SUBJECT: BRES2211-0012
BUILDING RESIDENTIAL

Here are the results of all Inspections located at **105 E D ST:**

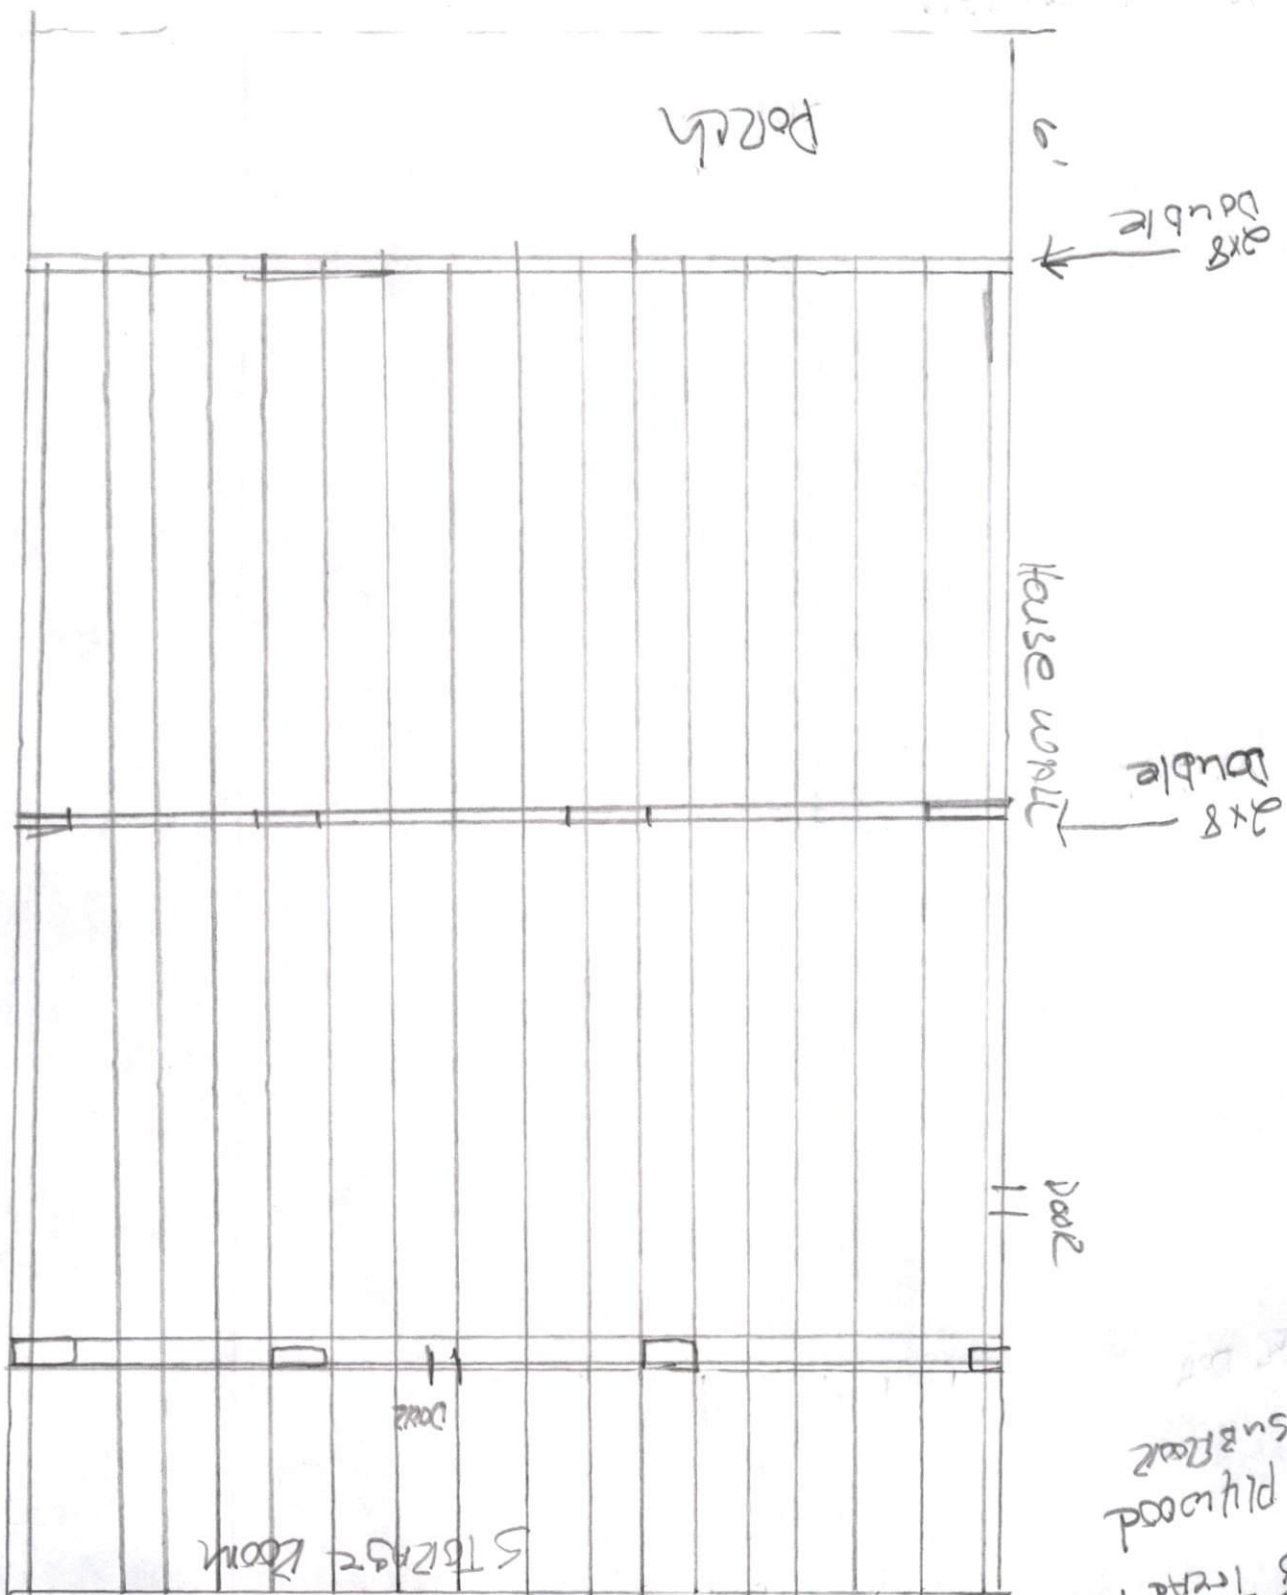
Riser height from porch to first step must be uniform with other risers. If there must be a riser that is not uniform and is shorter than the rest of the risers it must be from the bottom step to grade
